RE: REVIEW OF PREFERRED PROJECT REPORT AND RESPONSE TO SUBMISSIONS FOR PORT WARATAH COAL SERVICES TERMINAL 4, KOORAGANG (NEWCASTLE) (MP 10_0215)

ATTACHMENT A: OEH REVIEW OF PREFERRED PROJECT REPORT AND RESPONSE TO SUBMISSIONS FOR PORT WARATAH COAL SERVICES TERMINAL 4, KOORAGANG (NEWCASTLE)

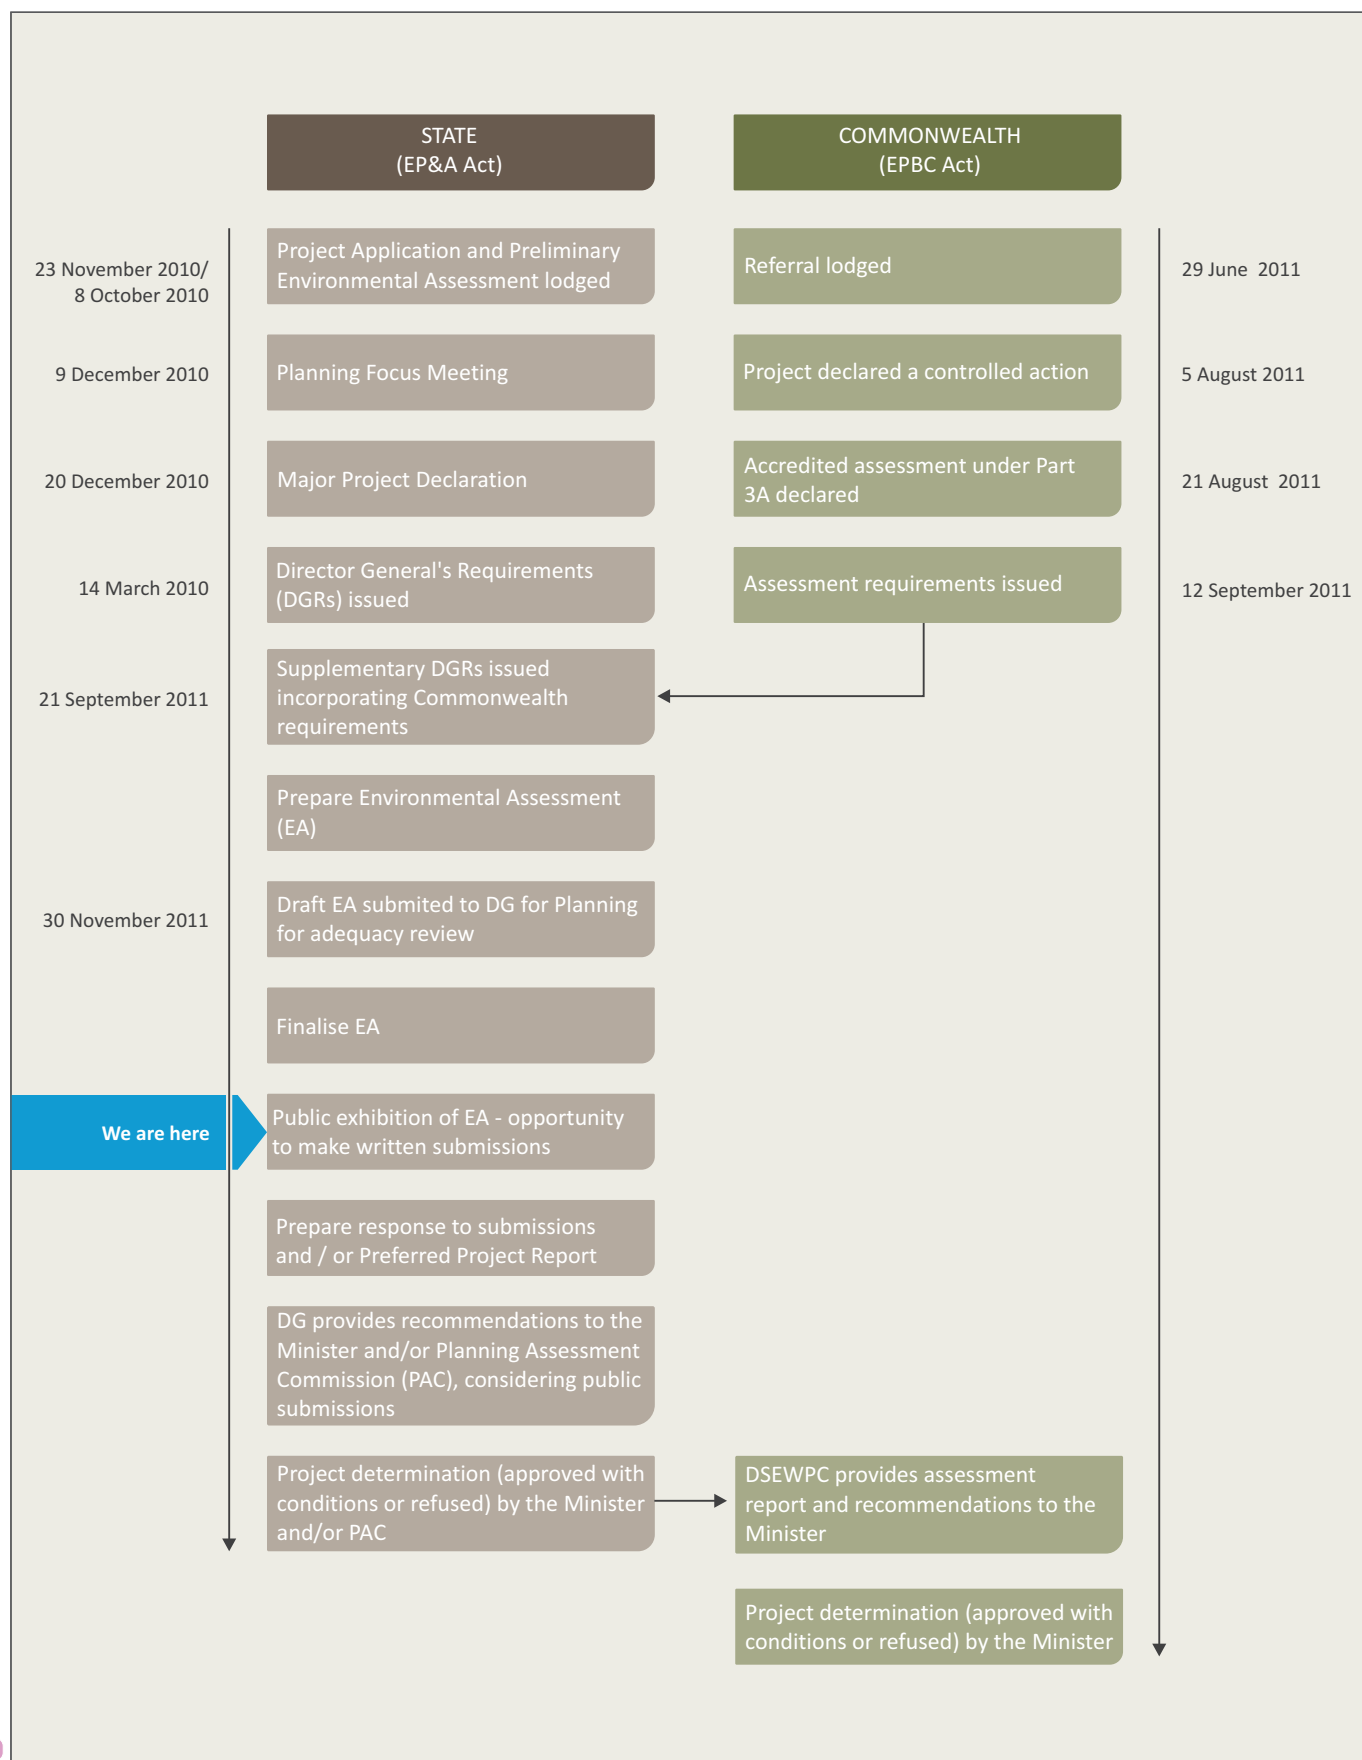
2. **Original EA Issue:** *The footprint appears to overlap NPWS estate north of the railway line, east of Mosquito Creek. NPWS understands that NPWS Estate (and RAMSAR area) occurs up to the railway line in this area, yet there is a discussion about the loss of Freshwater Wetland habitat (Appendix 4, Section 5.3.7.3, and Figure 4.1 also see Appendix J, Figure 8 for more detail).*

- **PWCS Response:** The Response to submissions documentation (Appendix L) indicates alteration to the existing levee height will mitigate any changes to the tidal regime.

- **PWG response:** Discussions have been held with PWCS subsequent to the EA exhibition and the matter will be dealt with through an REF process as the existing levee is on-park and is outside of the T4 footprint. PWG is satisfied that the matter has been dealt with through the additional studies and documentation.
